**City of Portland, Maine - Building or Use Permit Application**  
 389 Congress Street, 04101 Tel: (207) 874-8703, Fax: (207) 874-8716

<b>Location of Construction:</b> 120 FRONT ST	<b>Owner Name:</b> HAM MICHAEL L	<b>Owner Address:</b> 54 JOHANSEN ST	<b>Phone:</b>
<b>Business Name:</b>	<b>Contractor Name:</b> Ham Michael	<b>Contractor Address:</b> 54 Johansen St. Portland	<b>Phone</b> 2077750898
<b>Lessee/Buyer's Name</b>	<b>Phone:</b>	<b>Permit Type:</b> Single Family	<b>Zone:</b>

<b>Past Use:</b> Vacant Land	<b>Proposed Use:</b> Single Family Home- build a 26'x 34' Single Family Home	<b>Permit Fee:</b> \$1,095.00	<b>Cost of Work:</b> \$100,000.00	<b>CEO District:</b> 4
<b>Proposed Project Description:</b> build a 26' x 34' Single Family Home		<b>FIRE DEPT:</b> <input type="checkbox"/> Approved <input type="checkbox"/> Denied	<b>INSPECTION:</b> Use Group: Type	
		Signature:	Signature:	
<b>PEDESTRIAN ACTIVITIES DISTRICT (P.A.D.)</b>				
Action <input type="checkbox"/> Approved <input type="checkbox"/> Approved w/Condition <input type="checkbox"/> Denied				
Signature: Date:

REVISED: 09-27-2006: ADDED ONE EXISTING TREE TO REMAIN
 MINOR SITE PLAN FOR A SINGLE FAMILY DWELLING
 AT 118 FRONT STREET PORTLAND, MAINE
 FOR: MICHAEL HAM

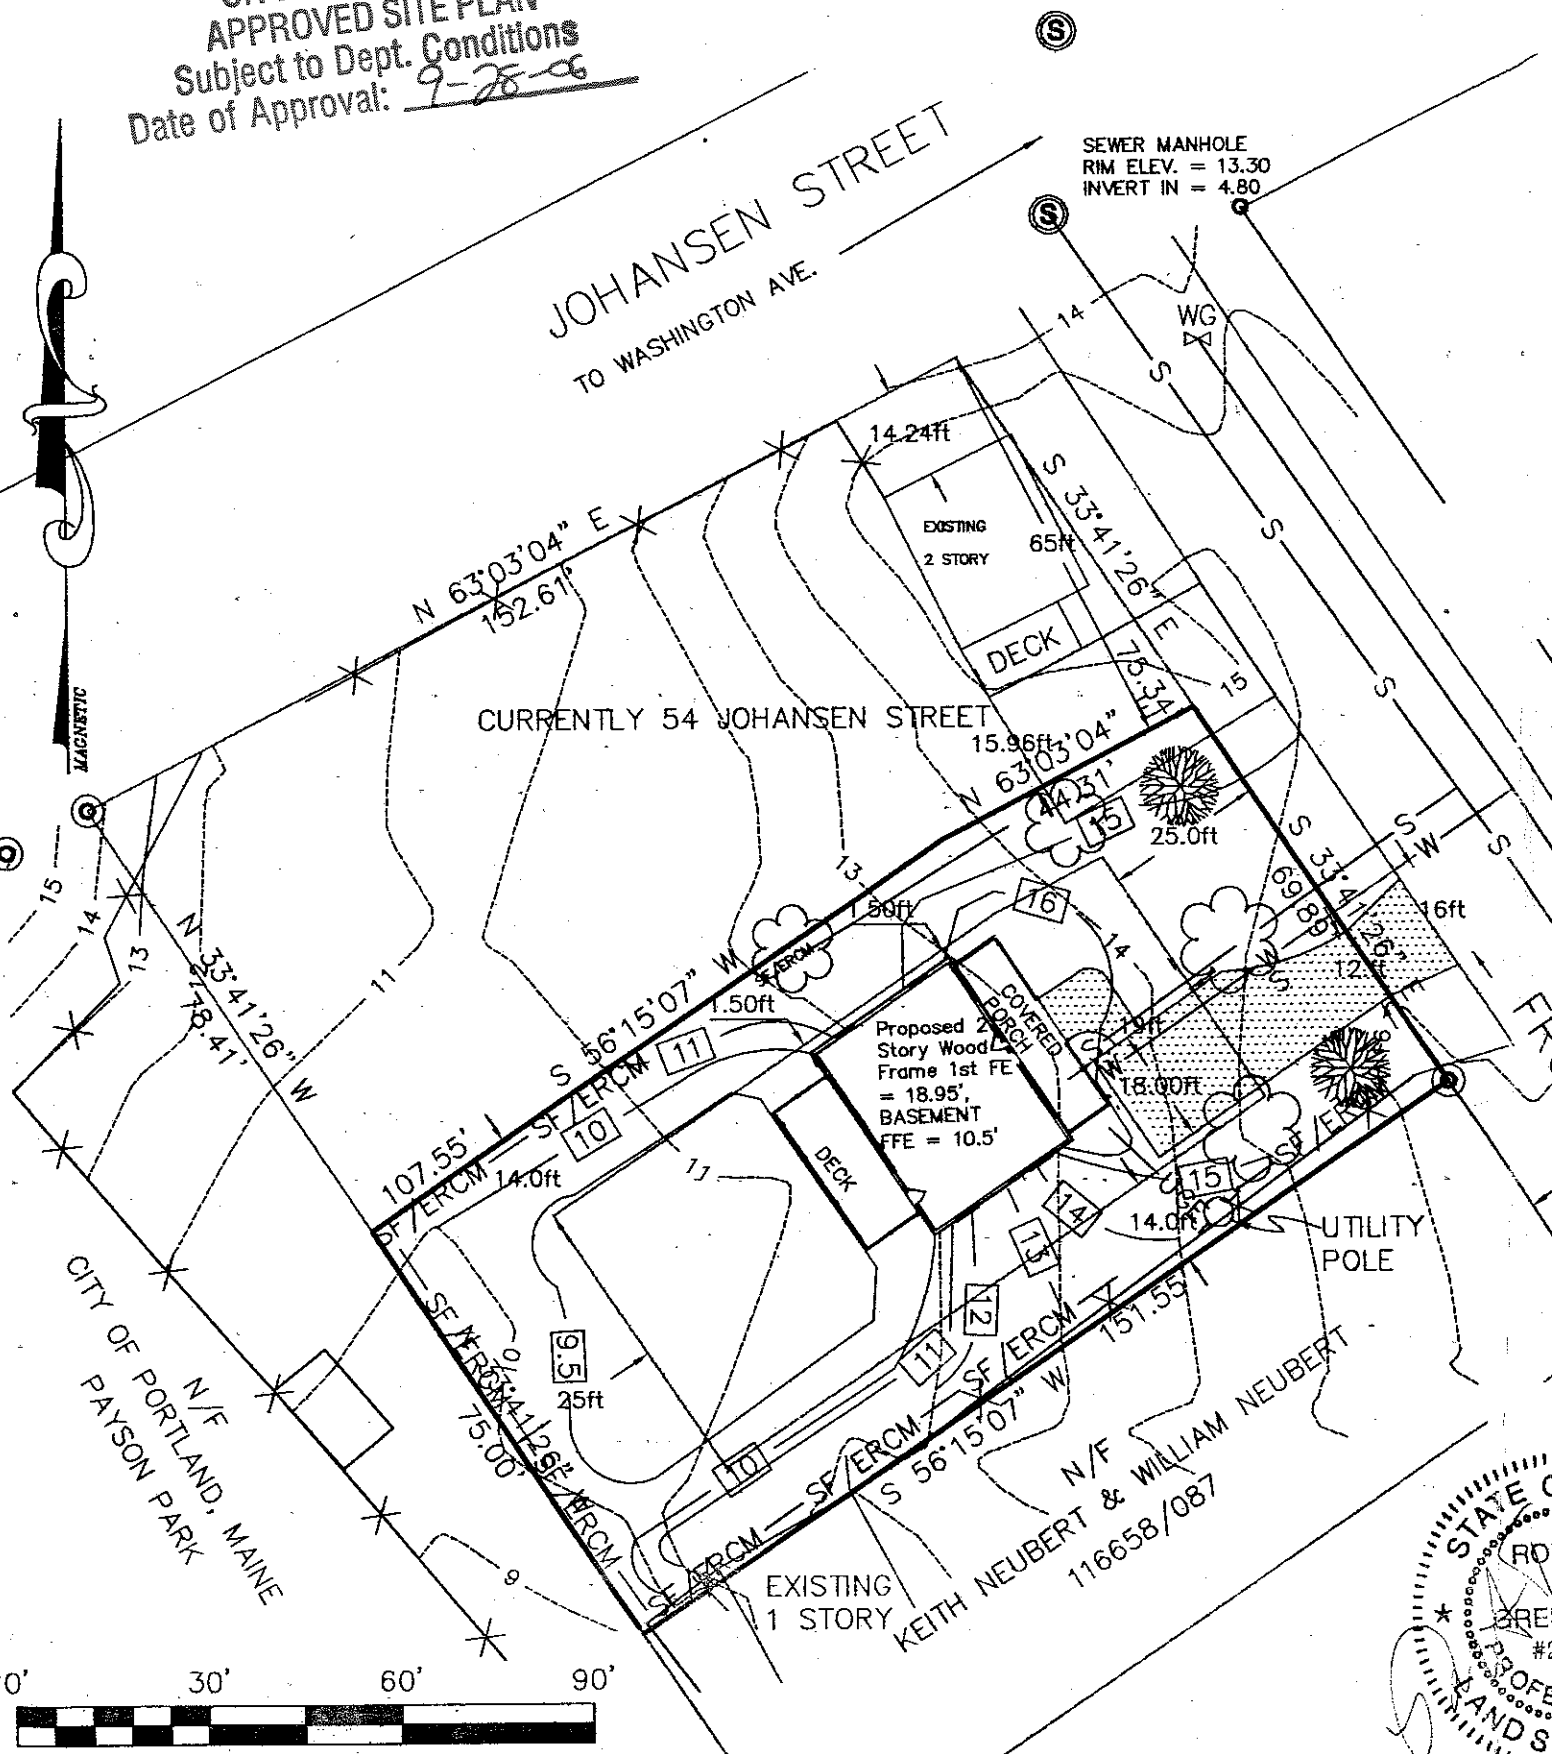
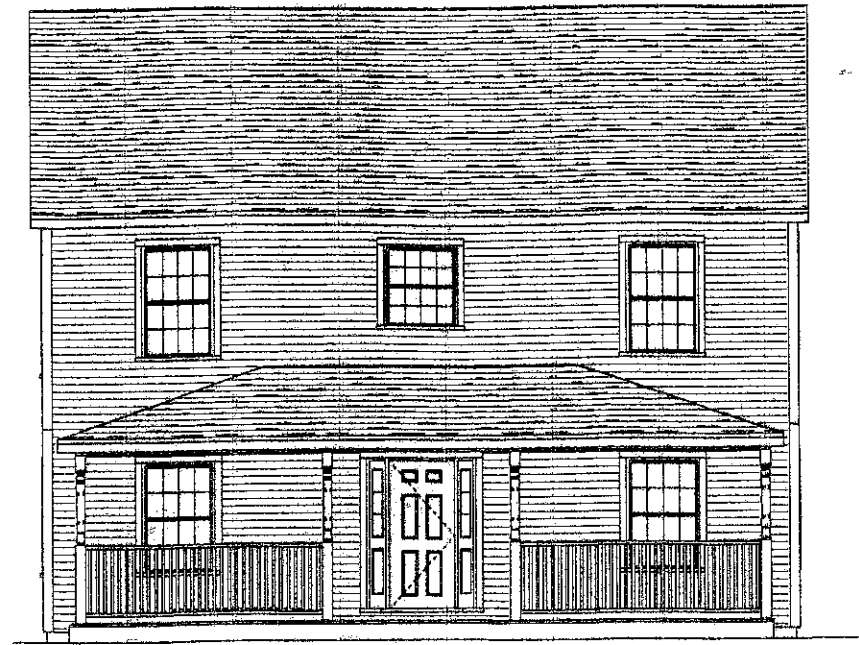
10/6/2006-mes: received revised plans - apparently plans given to planning only and not zoning originally  
9/18/2006-mes: the site plan does not match the building plans - no rear decks shown - no front farmers porch shown (much smaller stoop shown). Also must extend the driveway 1' to have two 9'x19' parking spaces outside of the required front yard (25') setback. Left message on Michael Ham's voice mail - In M's hold area
